WEST SUSSEX COUNTY COUNCIL CONSULTATION

TO:	Arun District Council - FAO: Simon Davis
FROM:	WSCC - Highways Authority
DATE:	02 June 2021
LOCATION:	Stakers Farm, North End Road, Yapton, BN18 0DU
SUBJECT:	Y/58/21/DOC Approval of details reserved by condition imposed under Y/44/17/OUT relating to conditions 6-tree protection, 7-drainage strategy, 8-surface water drainage, 9-maintenance & management of SuDS system, 10-Construction Management Plan, 11-contamination risk, 12-high speed broadband & 25-decentralised & renewable low carbon energy source.
RECOMMENDATION:	No Objection

Drawing Title
Engineering Details
Construction Method Plan

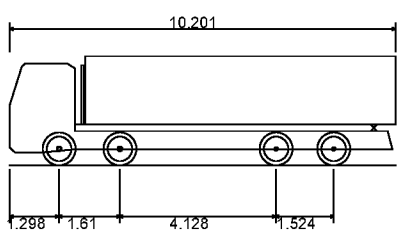
dedicated areas for this on site as shown by plan.

dedicated areas for this on site as shown by plan.

dedicated areas for this on site as shown by plan.

wheel wash point shown on plan.

The plans and details pertaining to condition 10 are acceptable.

Drawing Title
Large Tipper Vehicle Tracking
Proposed Site Access

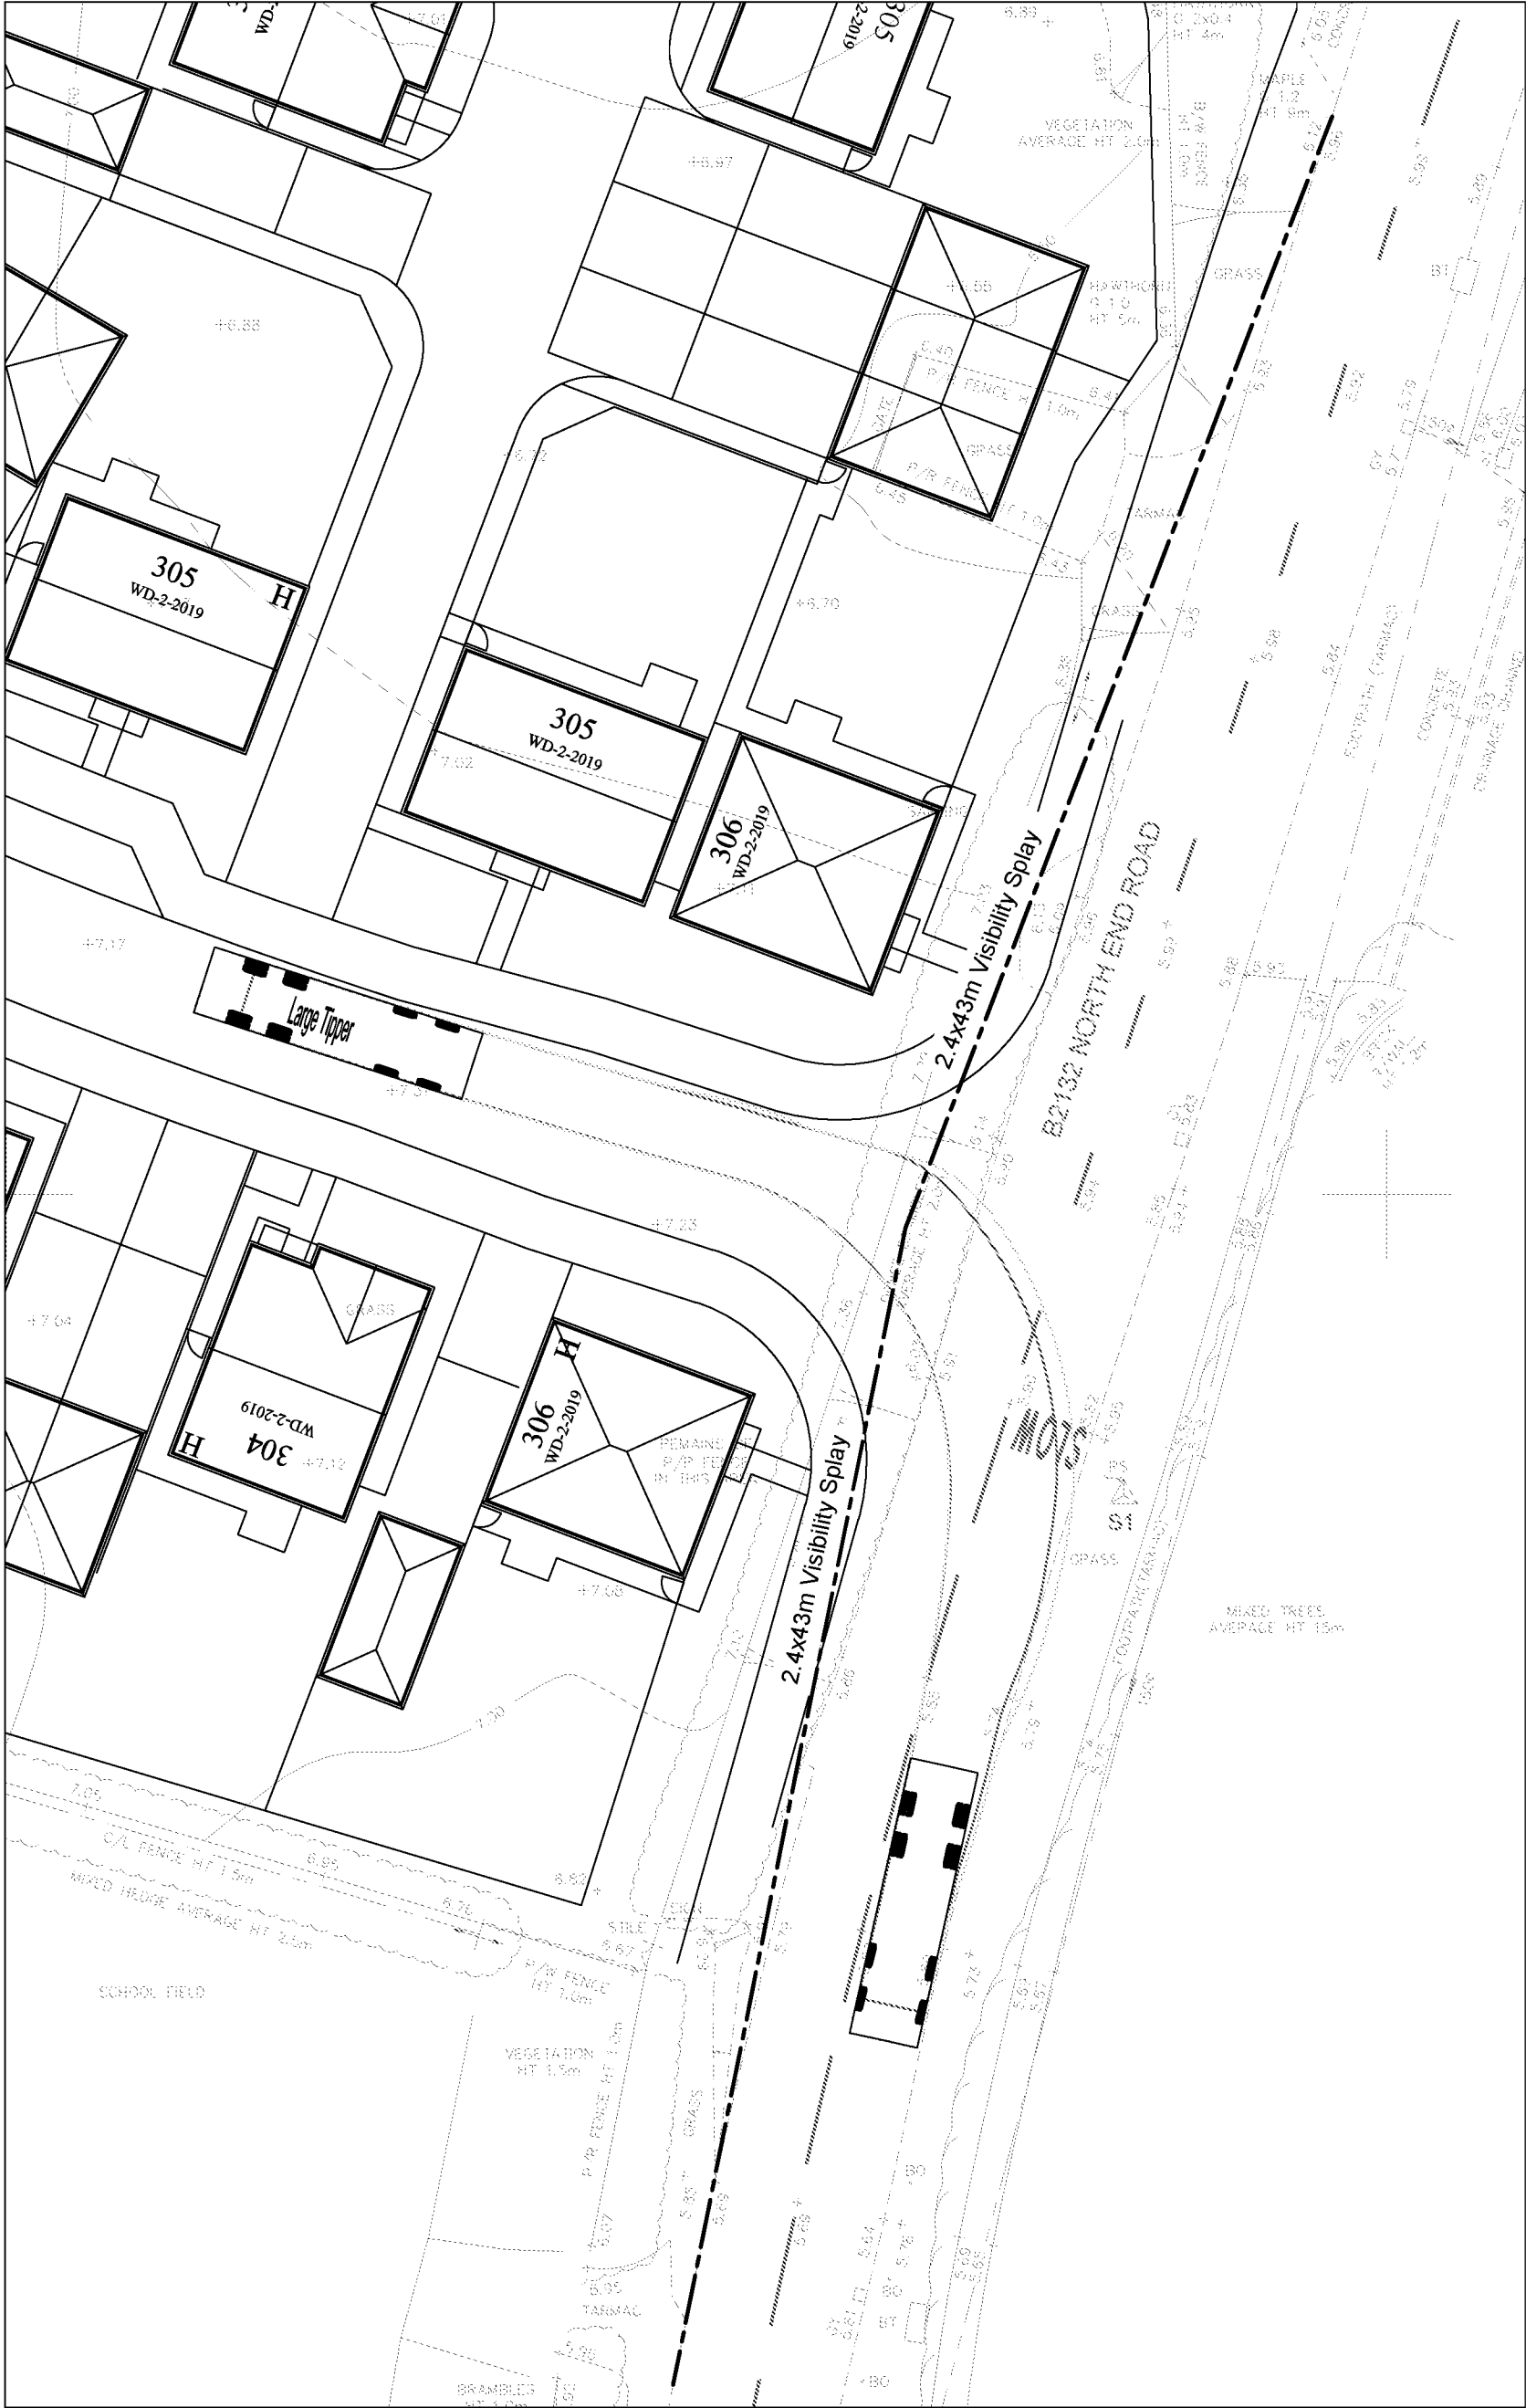
access via that approved under Y/17/20. Swept path tracking shows construction vehicles can manoeuvre this. Ford Road/Ford Lane will not be used, vehicles will be routed via main roads (North End Road via A27 to north).
